ENG-PUDSP22001-R1-GEC.pdf Markup Summary

PUDSP221

FOREBAY NO. 1 DETAIL  
SCALE: 1"=5'

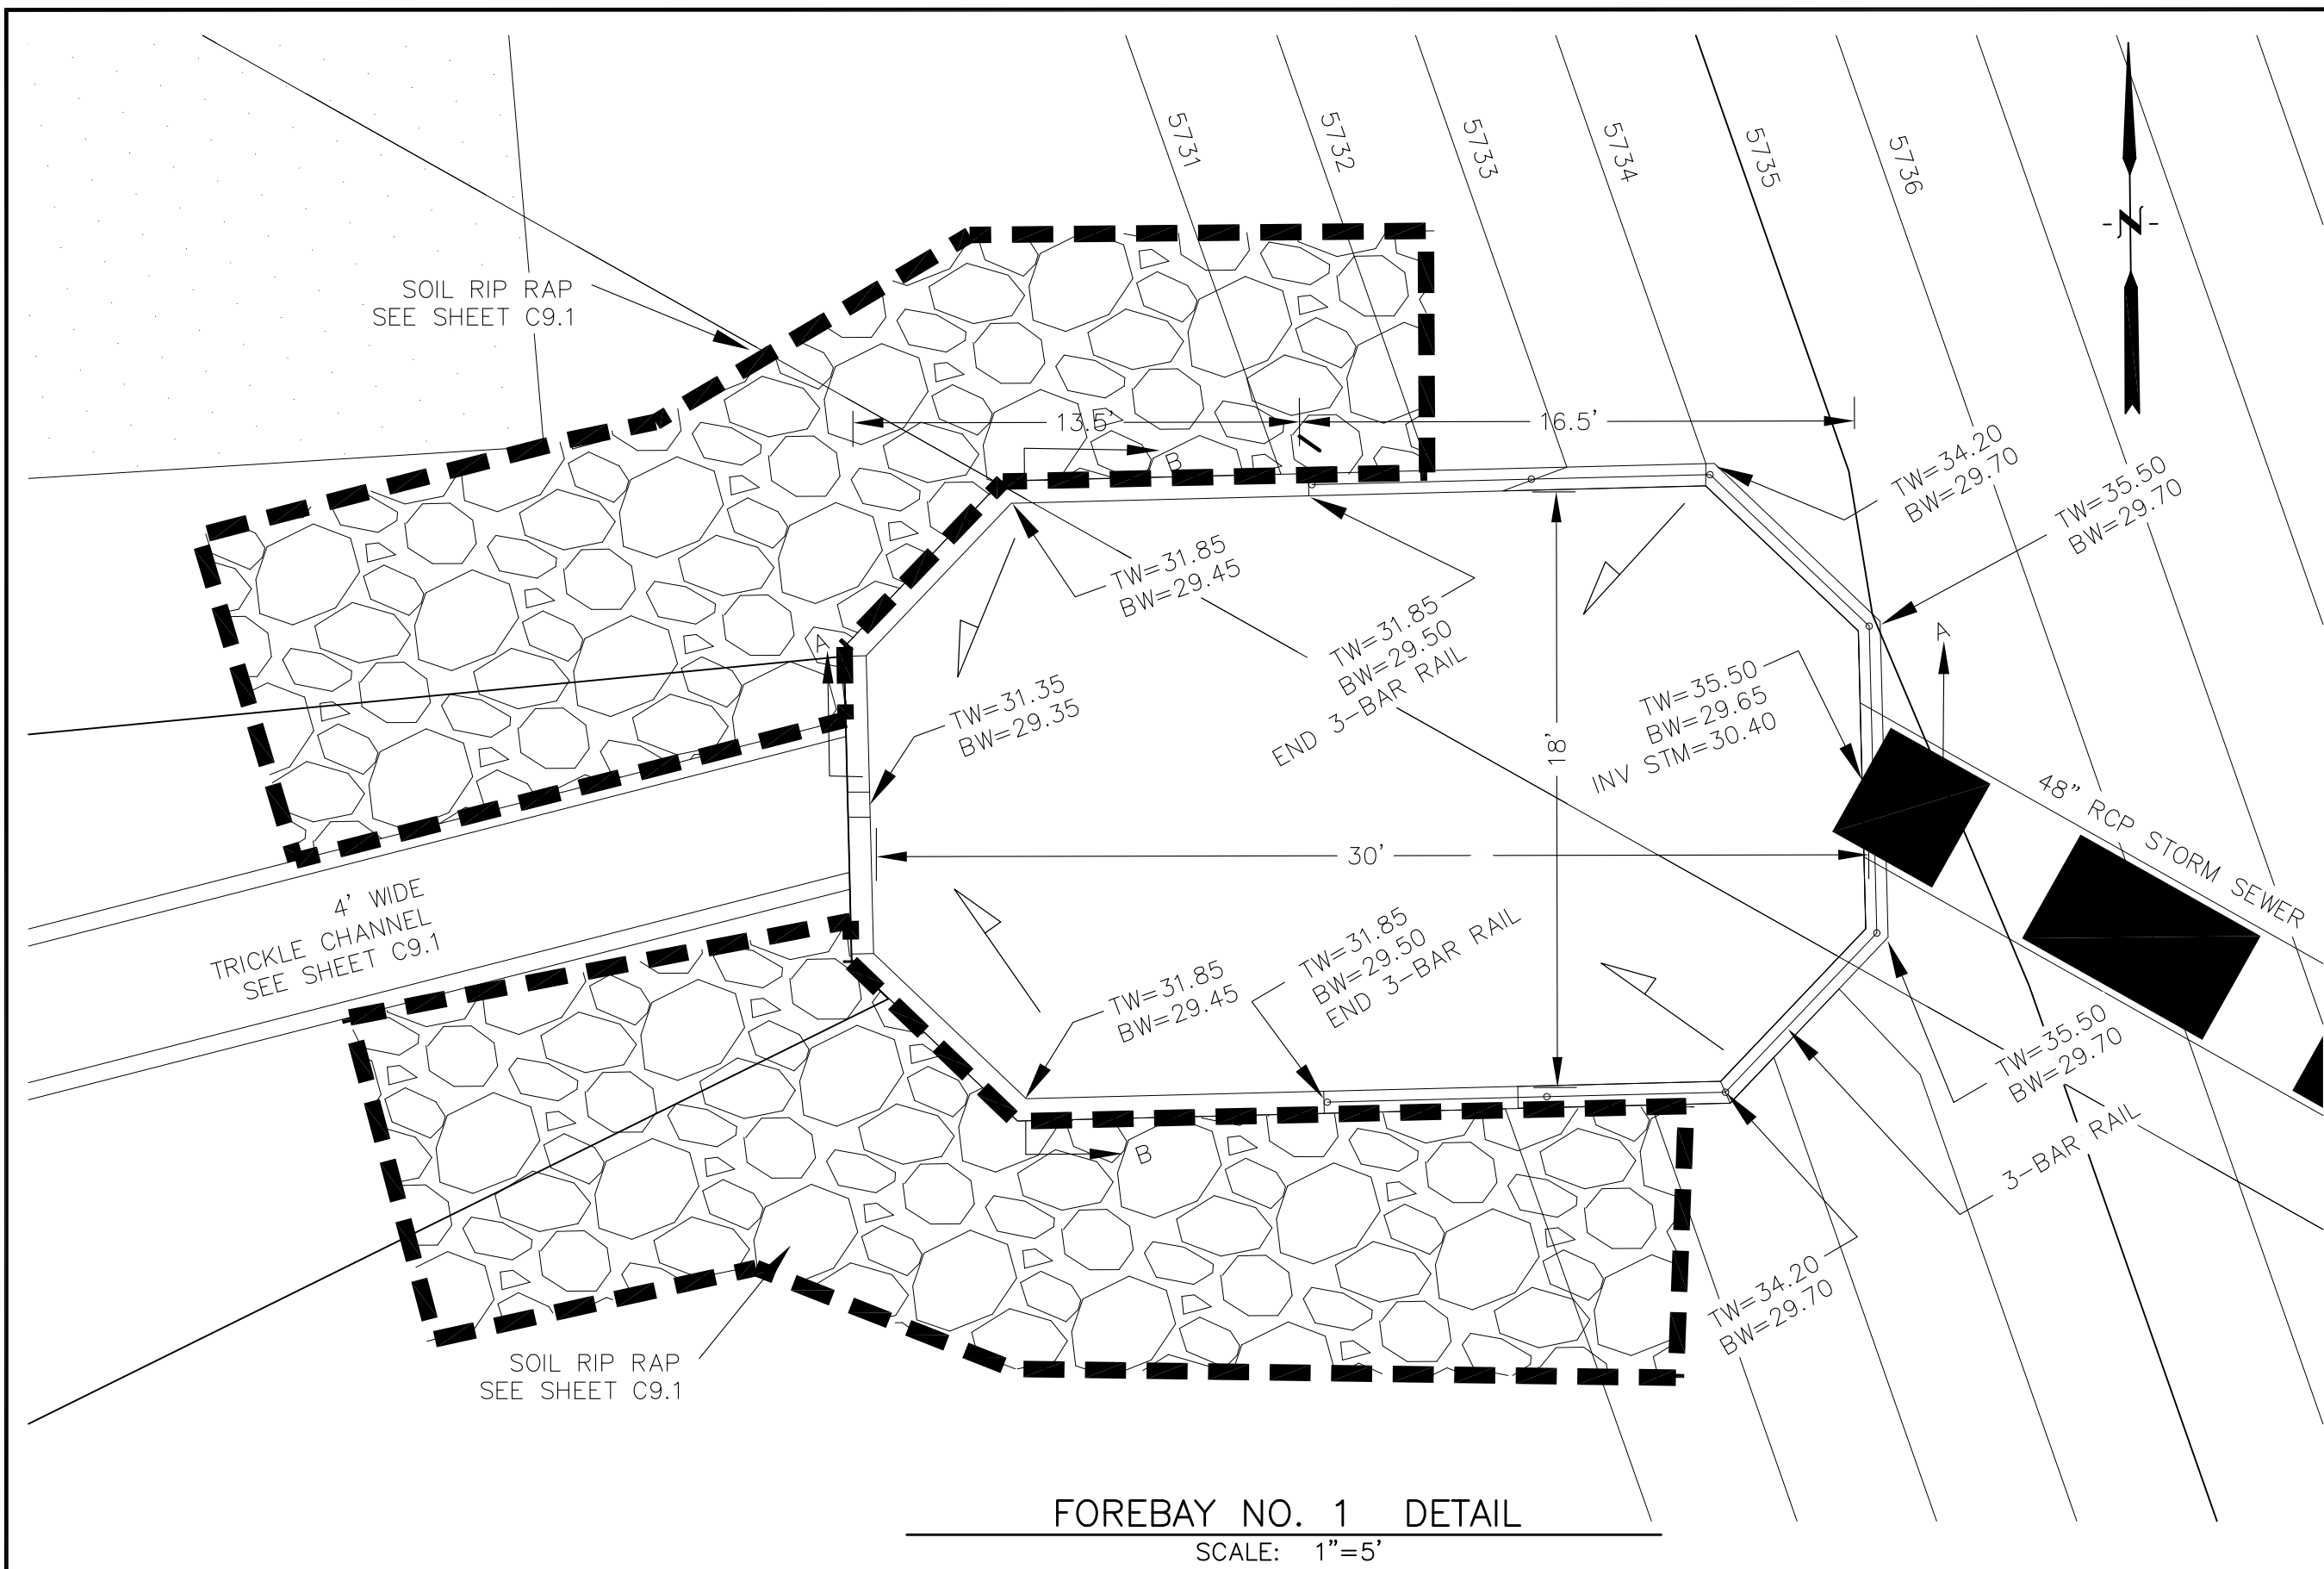
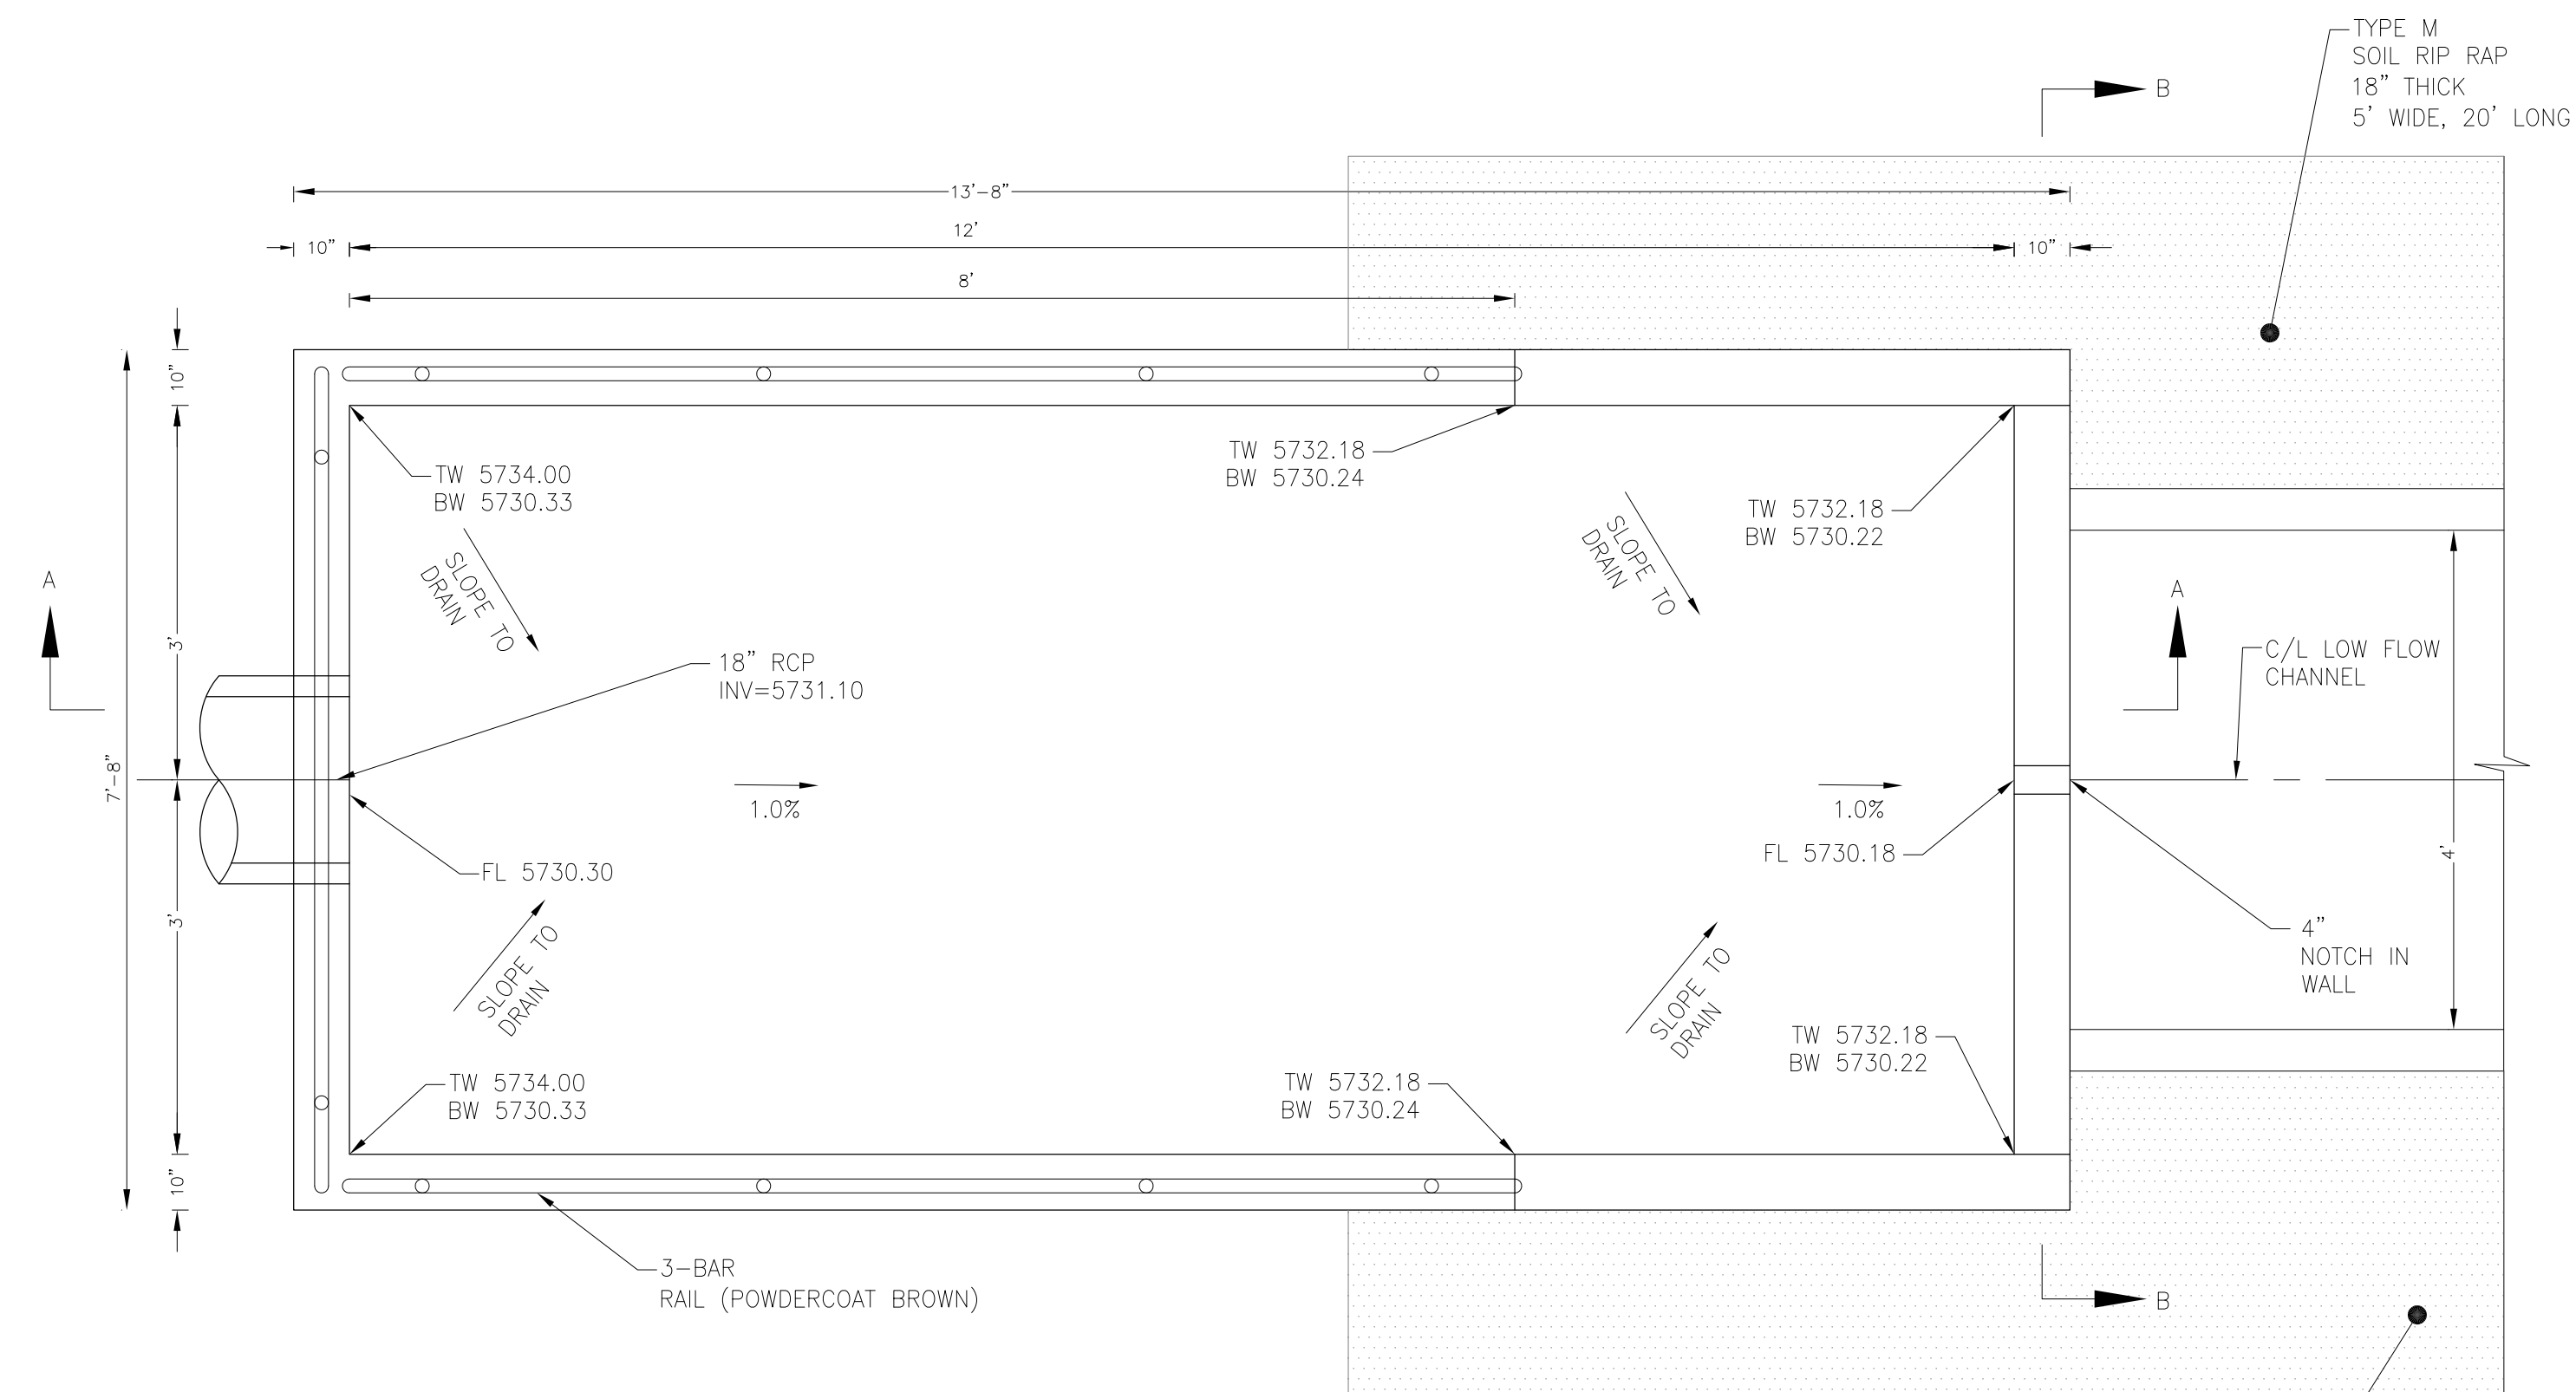
Per pdf pg 113 in PDR, this should be 9.5". But the 9.5" shown on that page is for if there was only one forebay for the whole pond. So you will need to show separate calcs for each forebay to determine notch size and volume for each.

double check volume calcs for the combined two forebays that they meet the min volume req's shown on pdf pg 113 of PDR.

show calcs for this notch in the FDR for final plat.
